**From:** Martyn White <Martyn.White@arun.gov.uk> on behalf of Conservation Officer <Conservation.Officer@arun.gov.uk>  
**Sent:** 03 December 2020 17:39  
**To:** David Pannell  
**Subject:** RE: 225 Poling Road, Arundel - Informal planning review.

**From:** David Pannell <[Smaviddavid@hotmail.co.uk](mailto:Smaviddavid@hotmail.co.uk)>  
**Sent:** 19 November 2020 10:24  
**To:** Conservation Officer <[Conservation.Officer@arun.gov.uk](mailto:Conservation.Officer@arun.gov.uk)>  
**Subject:** 225 Poling Road, Arundel - Informal planning review.

Title:
Proposed Internal Elevations

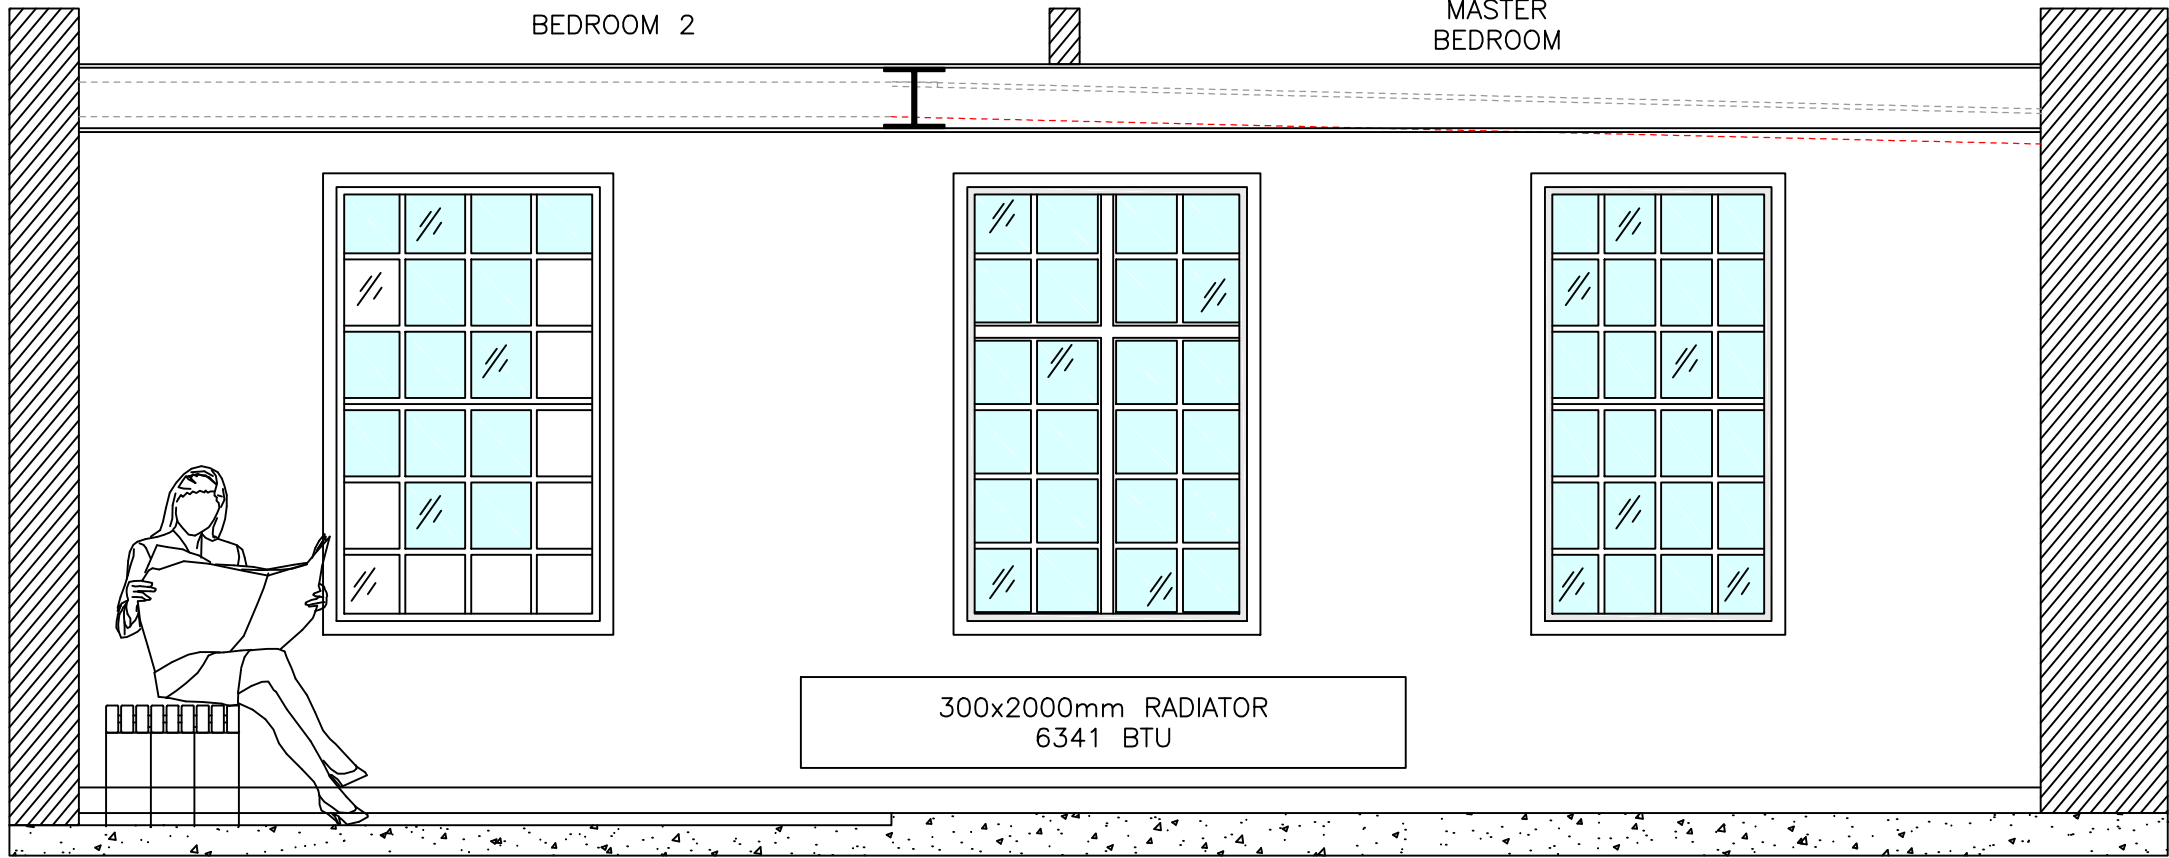
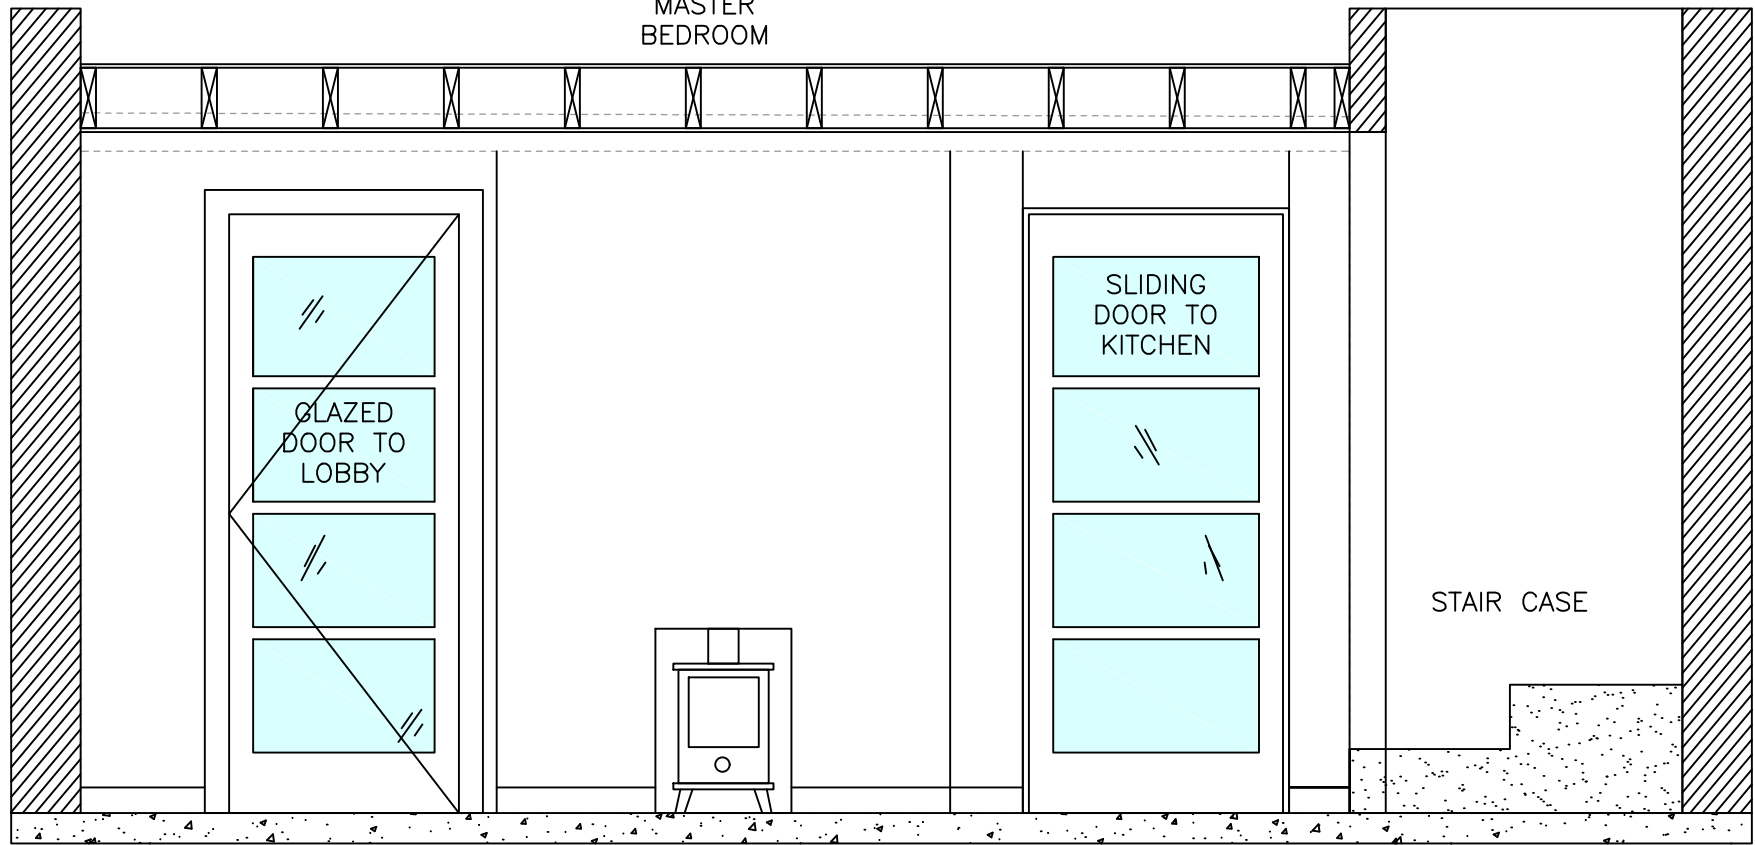
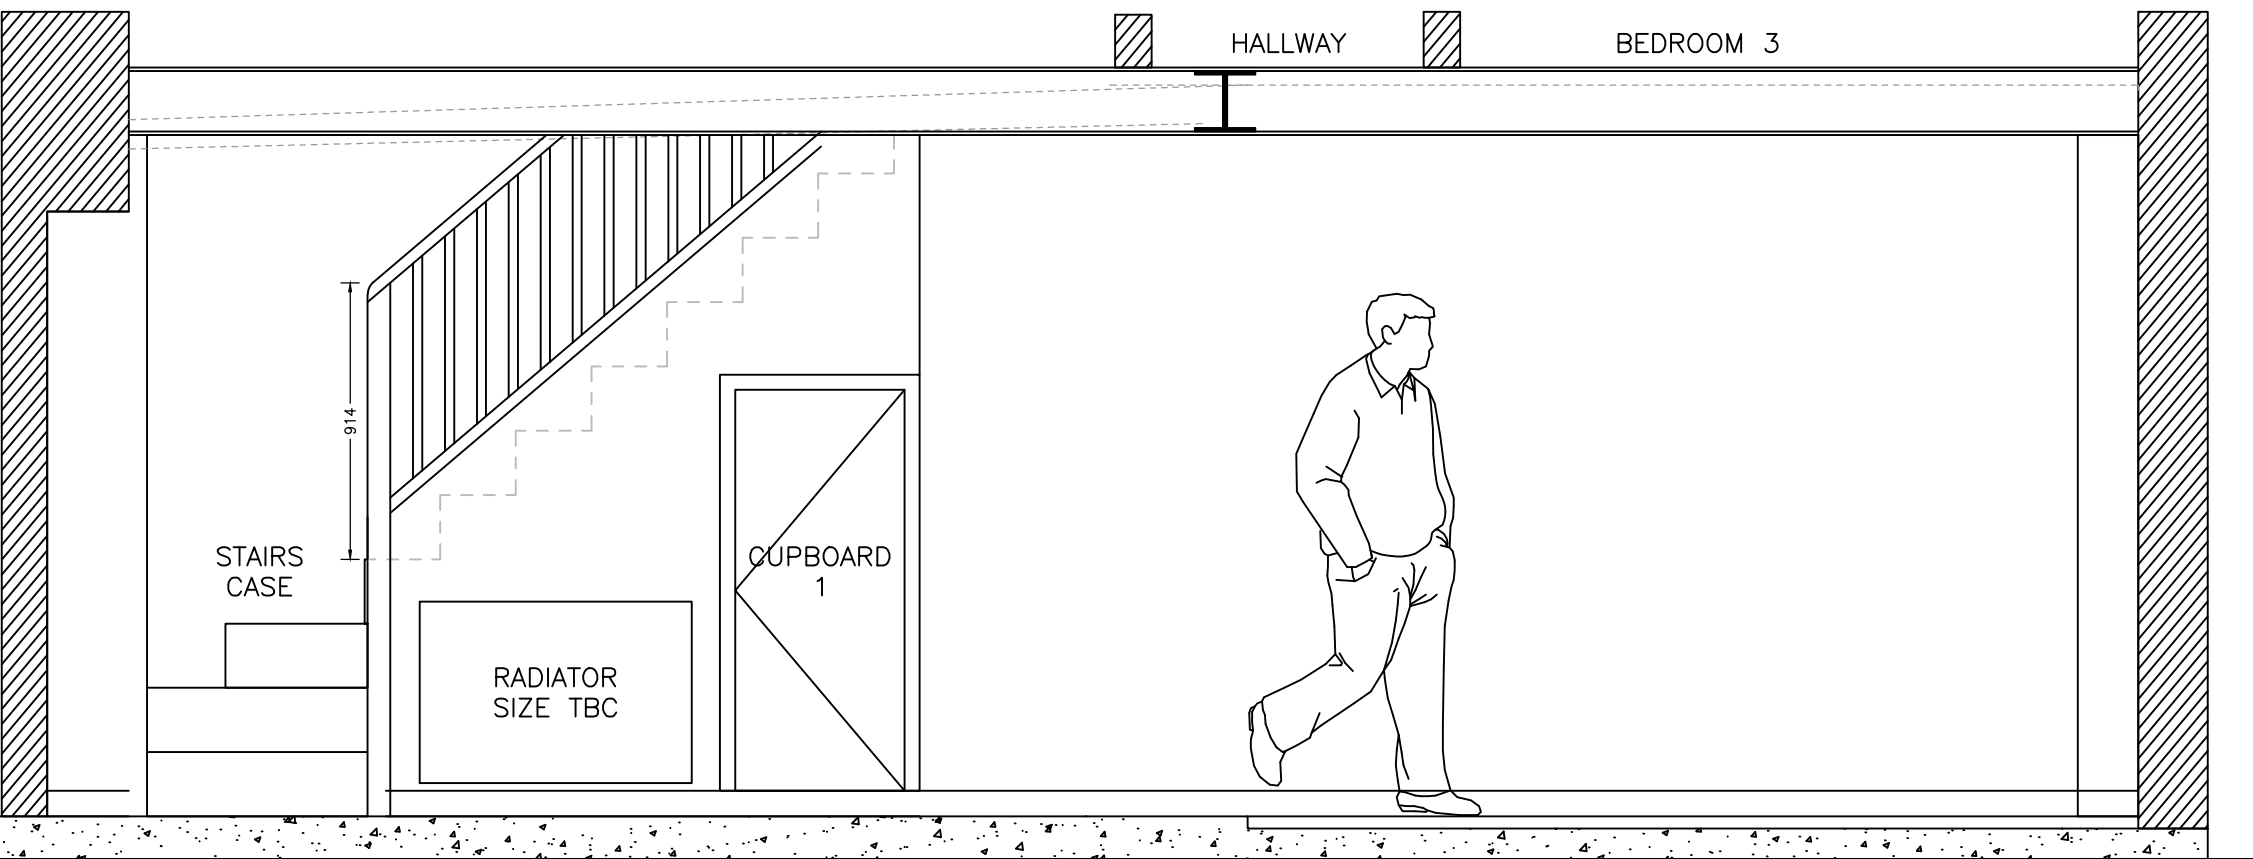
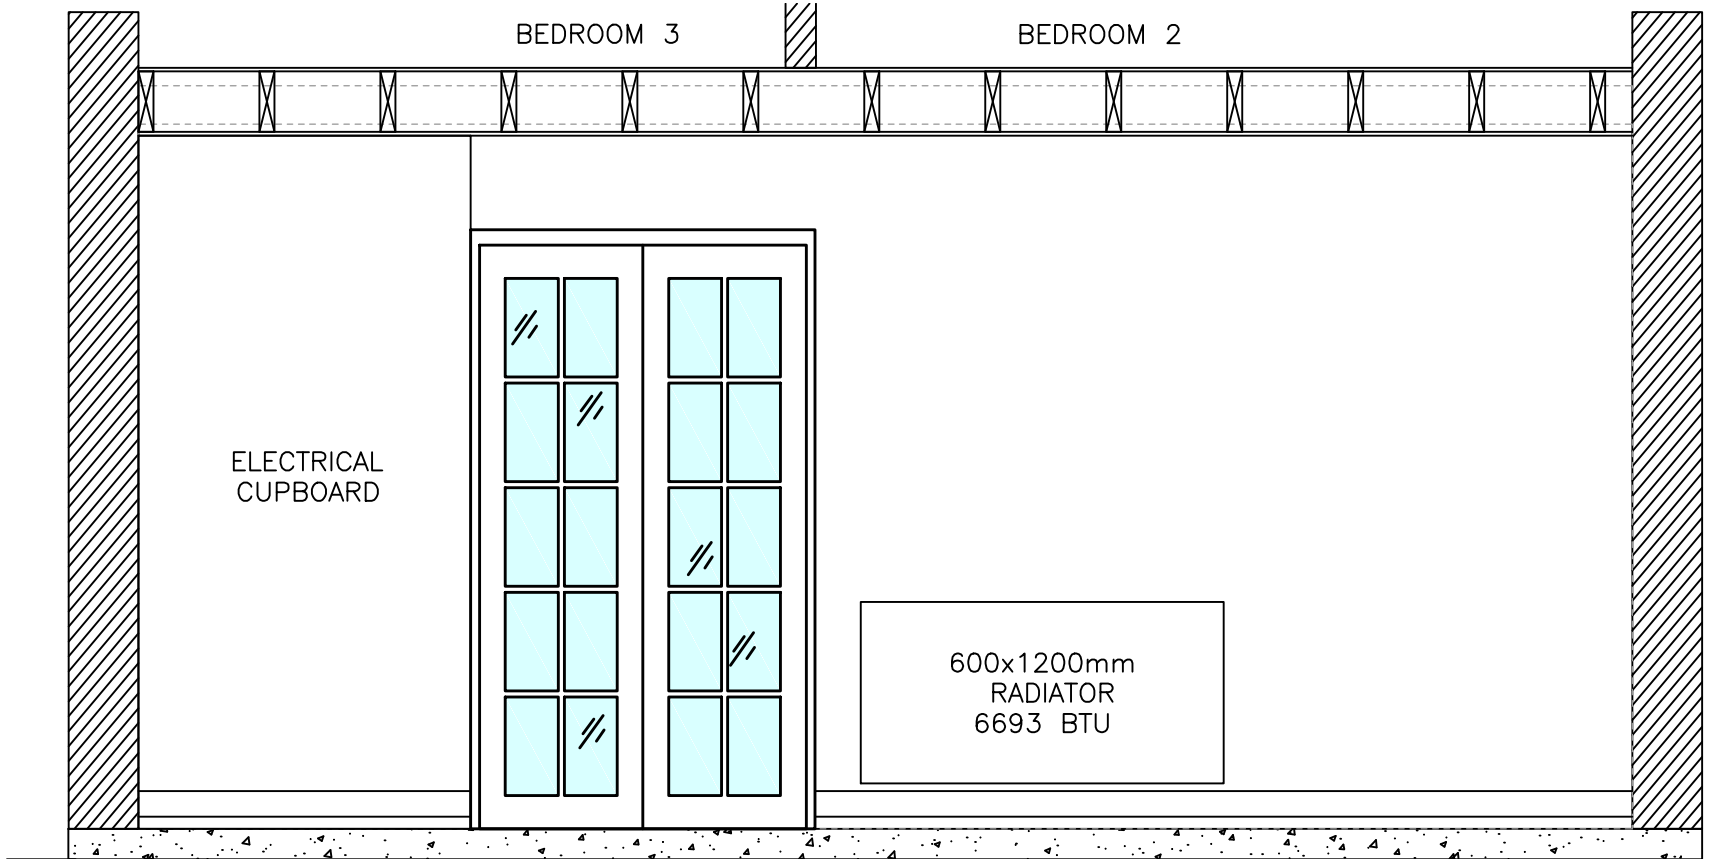
- Whilst the removal of the wall between the living/dining room seems to be ok, it is not clear if this is a historic wall, or a much more modern one. Normally, we would ask that small nibs of the wall are kept so that the presence of a former wall can be noted.
  - **Noted – I was aware you said this, but I had drawn this prior to our conversation, and thought I'd try it without, as the calcs came back not needing columns. I can look at exposing part of the wall to see its makeup. If the wall is of modern build, is it wrong to assume nibs are not needed? If they are, what size would these need to be and would it need to be on both sides?**  
You would be able to do so investigative work to look at the wall prior to submission of the consent in a couple of small areas. We normally ask for nibs as it might be the historic location of a wall even

- I note that you would like to remove the remainder of the chimney in the dining room and should point out that our normal approach would be to keep that in place.
  - The chimney itself has been fully blocked up and the top was removed prior to the listing I believe. My point/argument would be there is no external impact by removing the remainder of the chimney, and internally any features have been lost to previous renovations when the post office was removed, if not earlier.

- Whilst the removal of the wall between the living/dining room seems to be ok, it is not clear if this is a historic wall, or a much more modern one. Normally, we would ask that small nibs of the wall are kept so that the presence of a former wall can be noted.
- I note that you would like to remove the remainder of the chimney in the dining room and should point out that our normal approach would be to keep that in place.
- We would require any new bricks necessary to make good the removal of the existing vents to match the existing ones
- Do you have a preferred location for the new grilles as I note you identify two options? Also what will they look like, are you able to supply a picture of them as part of your application?

if it has been re-built and there is modern fabric present now. With regard to the nibs, they would not need to be big, just so that the line of the wall can be noted.

Ok, if an argument can be made as part of the application it should be ok in this instance
- We would require any new bricks necessary to make good the removal of the existing vents to match the existing ones
  - Will add a note to this on the drawing but this was the plan. I have several reclaimed bricks, and there were several in the shed which I hope will match.
